DEP Approval Request
 curb cut relocation
 Approve w/ Conditions

2005-0194
 Application I. D. Number
 8/29/2005
 Application Date
 single Family Home lot#7
 Project Name/Description

RE: Lot #11 Ballpark Drive - #371-A-041- R-2 Zone - application #05-0461

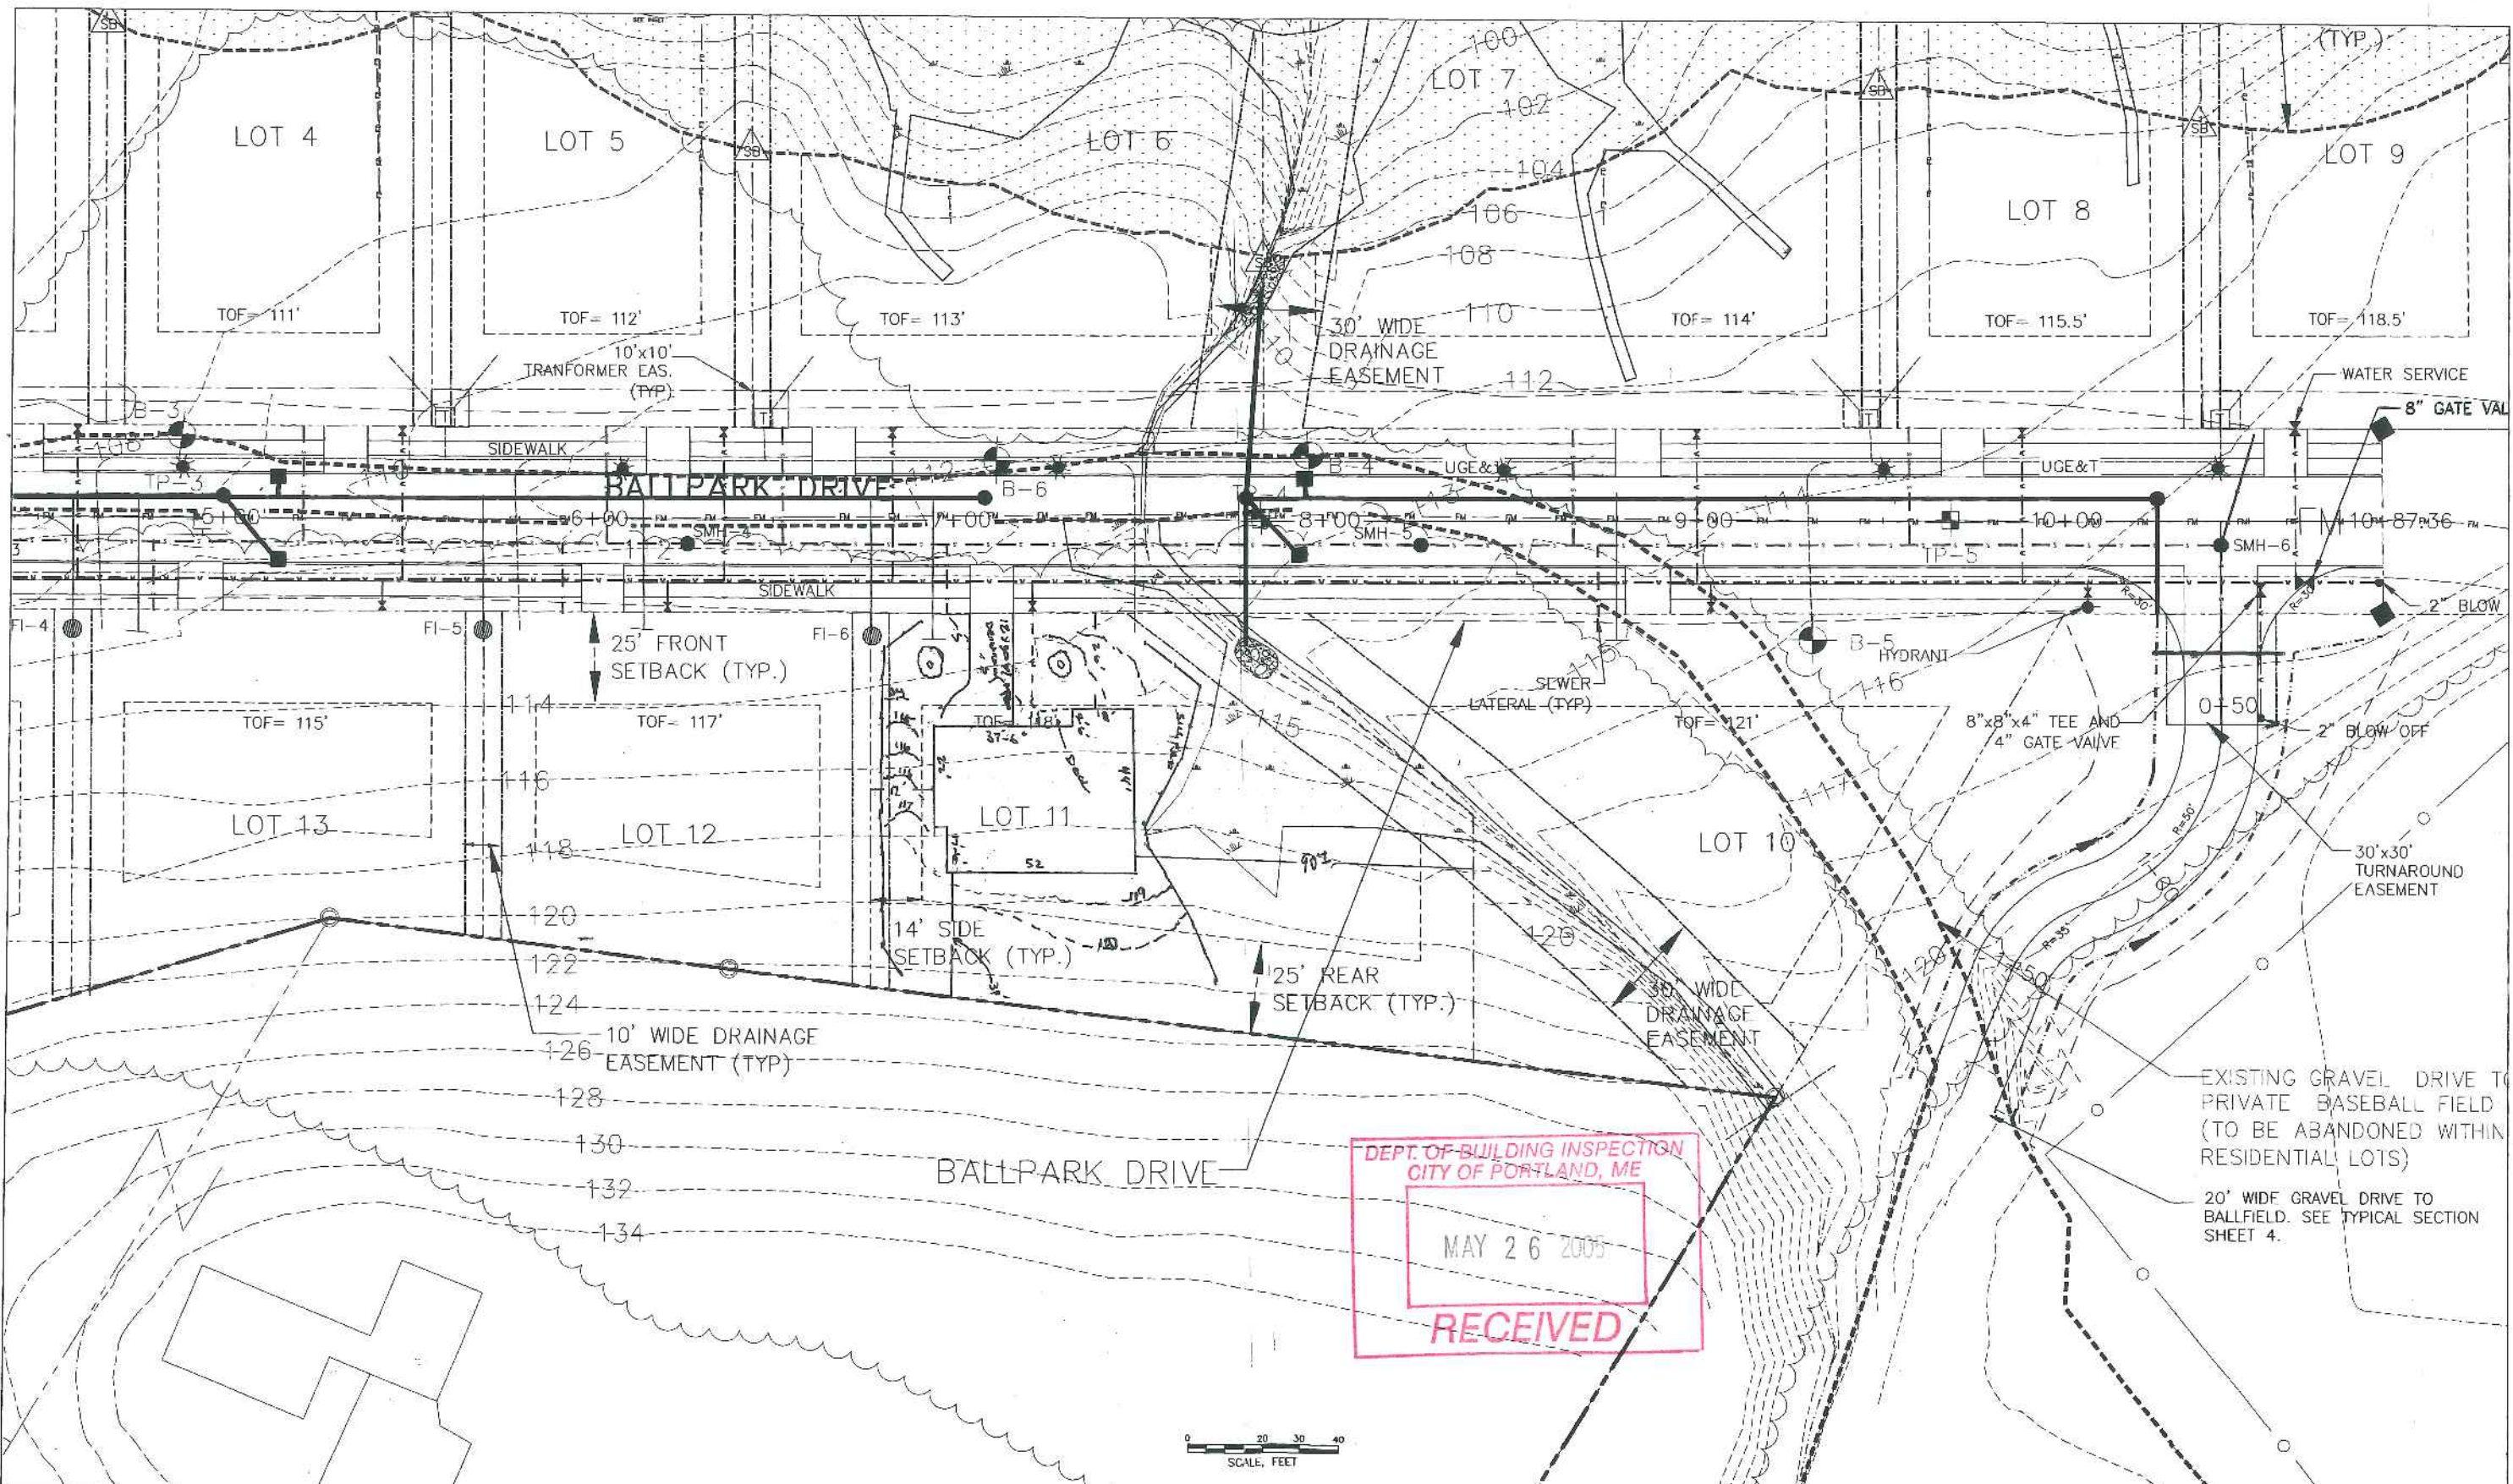
You have not submitted a scaled site plan showing the proposed, dimensioned structure. Your currently submitted site plan does not match your submitted building construction plans. Your site plan must show all projections, including, but not limited to, decks, stairs, chimneys, and bay windows.
